From: [Simon Halcrow](#)
To: [Michelle Niles](#)
Cc: [David O'Connell](#)
Subject: RE: Notice of Modification Request - Casuarina Town Centre Project Approval (MP 06_0258 MOD 12)
Date: Friday, 8 February 2019 3:42:11 PM
Attachments: [image001.png](#)
[image002.png](#)
[image003.jpg](#)
[image004.jpg](#)
[image005.jpg](#)
[image006.png](#)
[image007.jpg](#)
[image008.jpg](#)
[20190125 - J150 - Engineering Assessment V3.pdf](#)

From: Michelle Niles [mailto:Michelle.Niles@planning.nsw.gov.au]
Sent: Friday, 21 December 2018 3:48 PM
To: Simon Halcrow <simon@planitconsulting.com.au>
Subject: Fwd: Notice of Modification Request - Casuarina Town Centre Project Approval (MP 06_0258 MOD 12)

The proposal seeks approval to subdivide SP 94481 into two separate allotments, to correct an error in the Survey undertaken during works associated with MOD 6 which incorrectly amalgamated a car parking lot and medium density housing lot.

PROPOSED SUBDIVISION PLAN

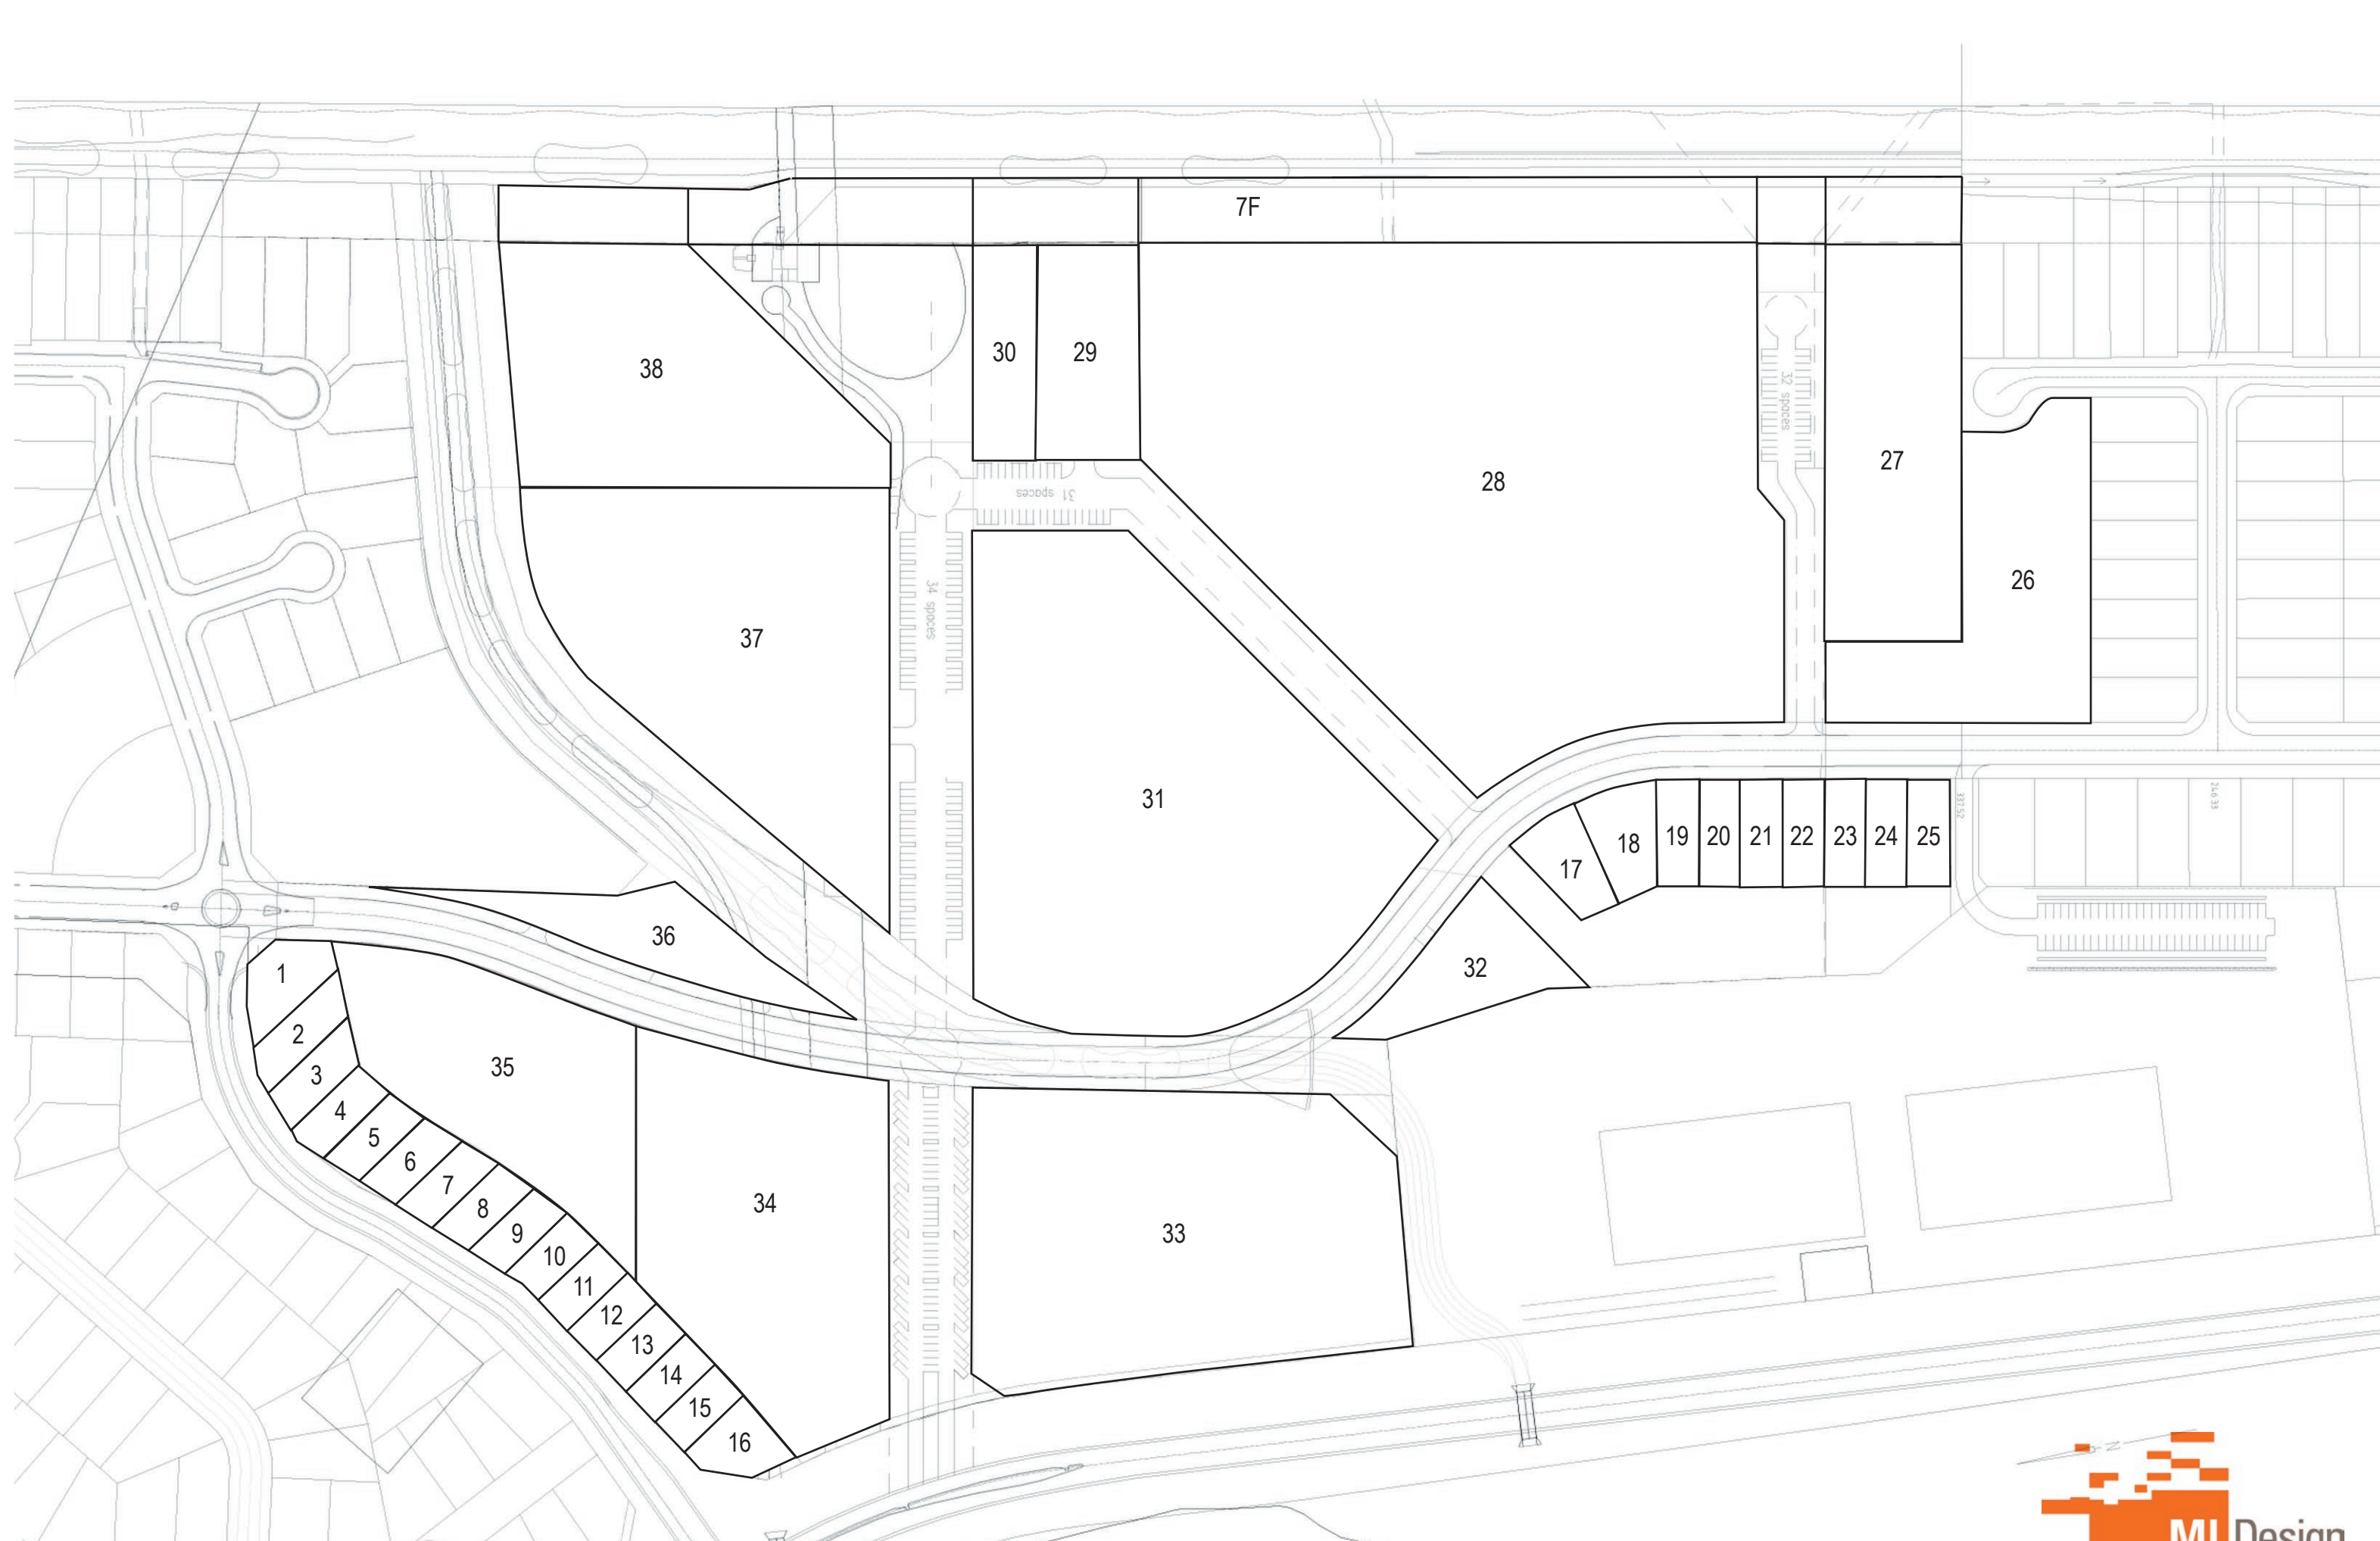
The submitted application indicates that the original approval and overall intention of the development was for the car park lot to be a separate torrens title allotment, with the Appendix A Subdivision Plan (dated 10/10/2006) submitted in support of this. Clarification is sought as to whether this plan was ever approved in support of the applicant's assertion. A search of records by Council staff does not indicate that this plan was ever approved by the Department of Planning and was instead superseded by an alternate layout through the 'Response to Submissions' assessment of the original application.

1. The applicant has referenced a drawing in their appendix A - "Proposed Subdivision Plan dated 10/10/2006 by MLDesign" as an approved plan indicating that the car parking area was a separate lot to that of the medium density lot. All consent approvals do not indicate that this drawing was approved as part of the original consent. Clarification may be required from the applicant where this drawing was approved as part of the consent.

Response: The Medium density lot (totalling 8679m²) has always been intended for medium density development as part of Stage 1C whilst the Car Parking Lot (totalling 928.2m²) contains a constructed car park, as demonstrated from Concept Approval through all modifications. This car parking allotment is maintained as intended for the provision of car parking spaces for the Casuarina Town Centre locality. The Stage 1C Lot (3) is for medium density development which has since been incorrectly registered on title to include the medium density allotment and the car parking allotment as one parcel of land and registered as Lot 16 in DP1198266. Which occurred as part of Mod6 and the introduction of the additional sub-stage 1C. The car parking allotment is most recently demonstrated as a separate parcel and under a separate stage (being Stage 1A) on the approved plans for Mod 6 (titled *Development Staging Plan* By Newton Denny Chappelle dated 17/10/13 with ref. 12/111B), is shown again in the plan set for Mod 7, as well as the concept approval plan set.
